October 19, 2021

**Re: Kiddie Academy  
4590 Paradise Blvd  
30-Day Temporary Certificate of Occupancy  
Transportation Development Final Inspection  
Engineer's/Architect's Stamp dated 6-17-20 (C12D003A)  
Certification dated 10-15-21**

Ernie Gomez,  
Plan Checker, Planning Dept.  
Development Review Services

A1 TRAFFIC CIRCULATION LAYOUT PLAN
 SCALE: 1/8" = 1'-0"

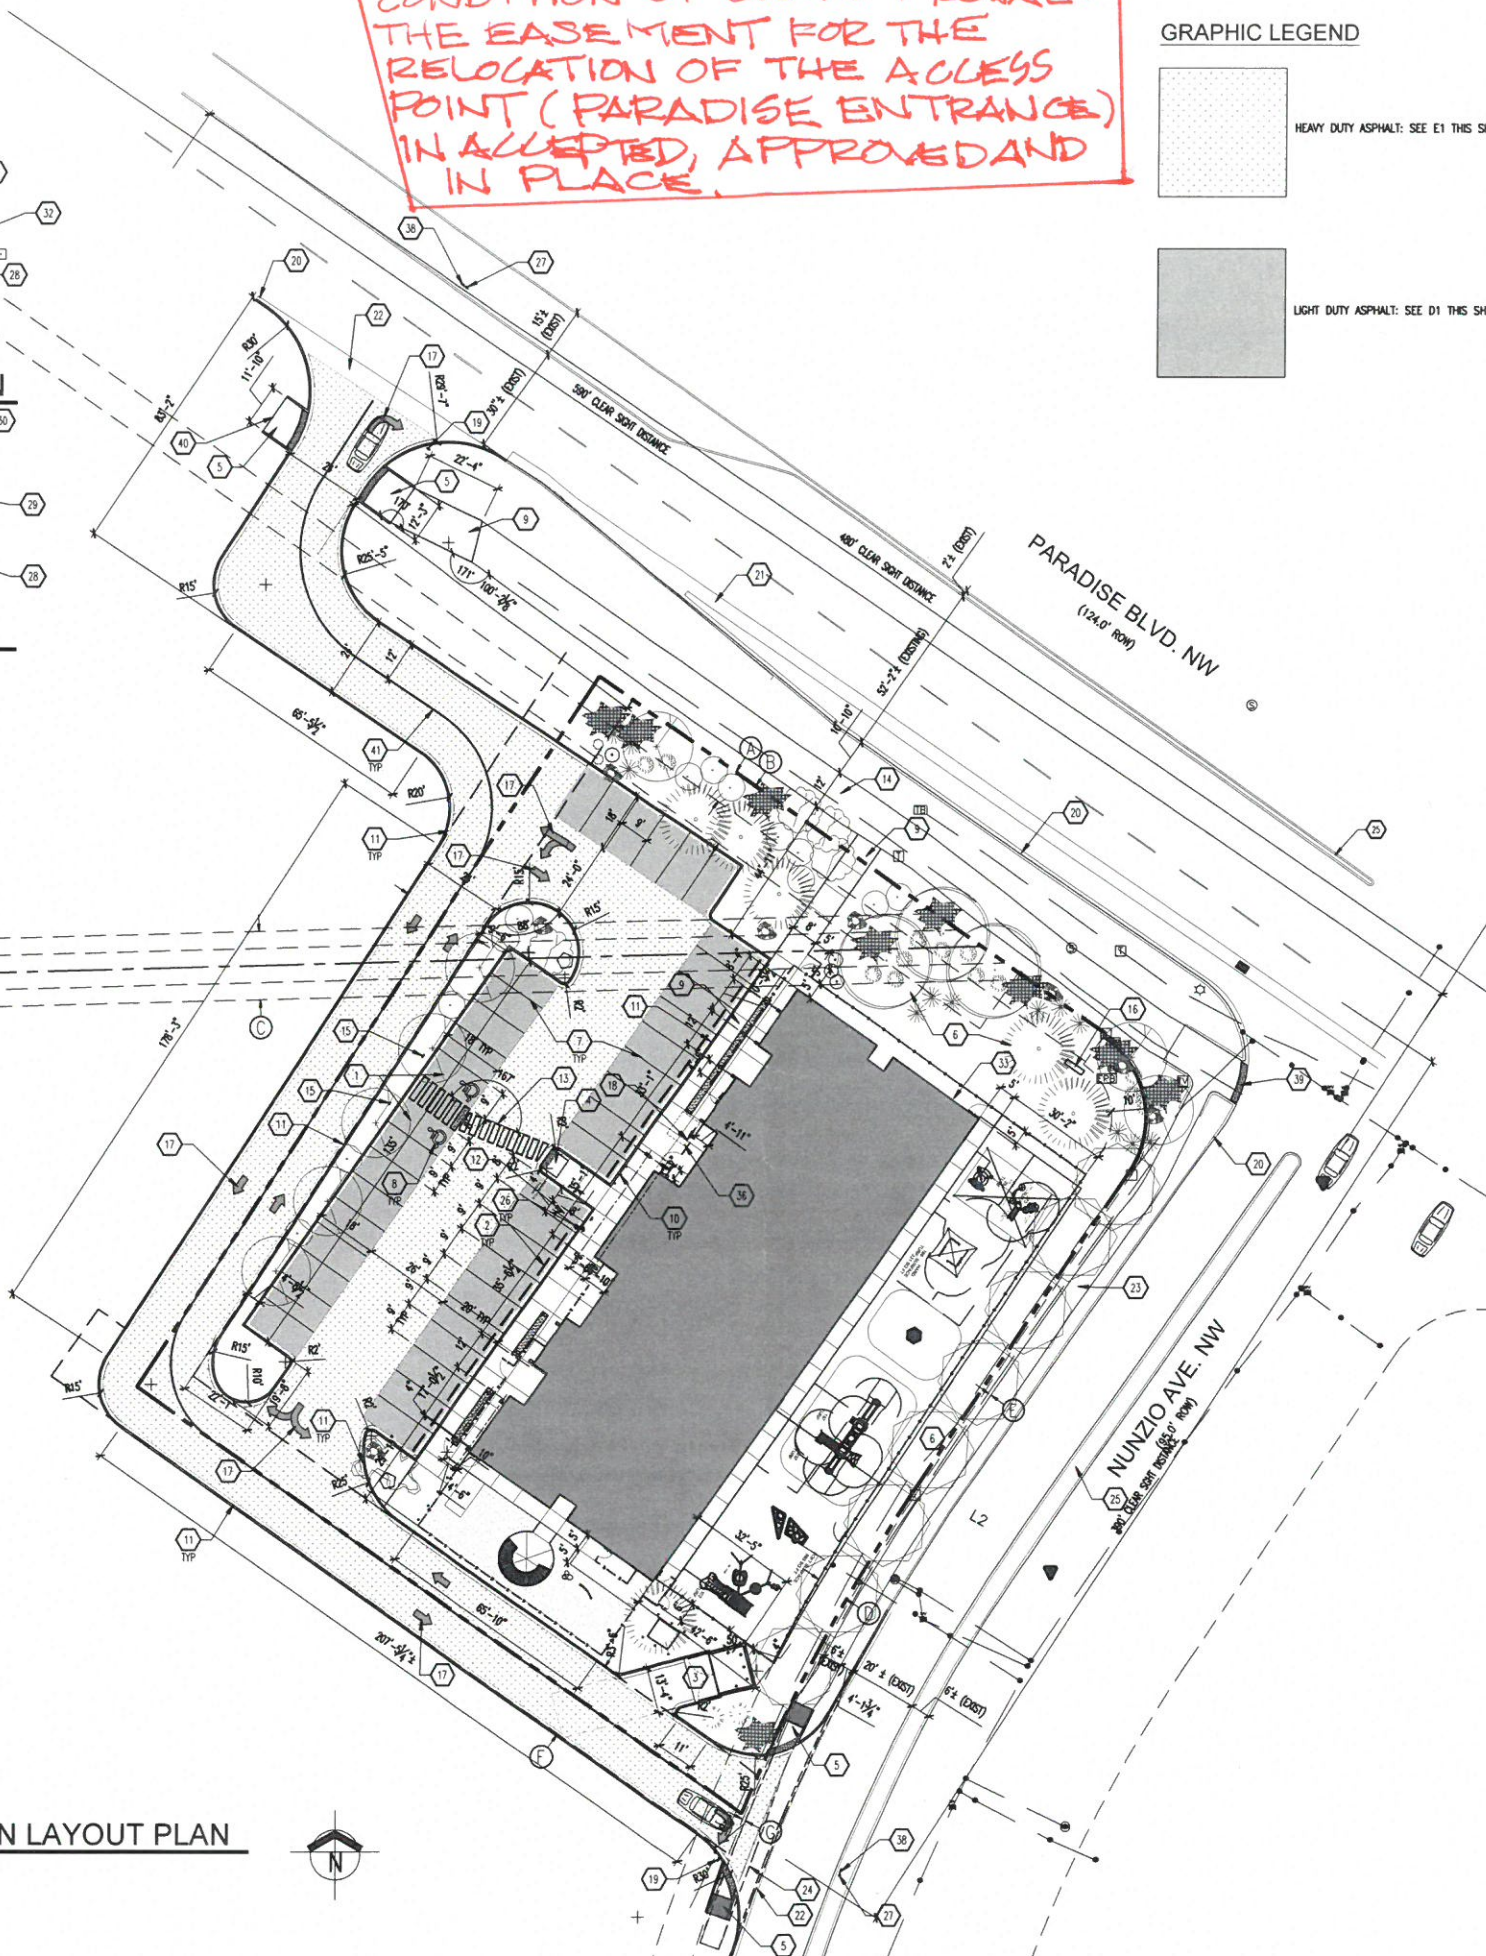
- Please redline plan to reflect the concrete curb and gutter extension in front of the 2 parking stalls. Label the 2 stalls as compact.
- Remove Porta potty, trash container, construction equipment and debris from site.

Once these corrections are complete, email pictures & redlined TCL plan showing the changes to [epgomez@cabq.gov](mailto:epgomez@cabq.gov) for release of Final CO.
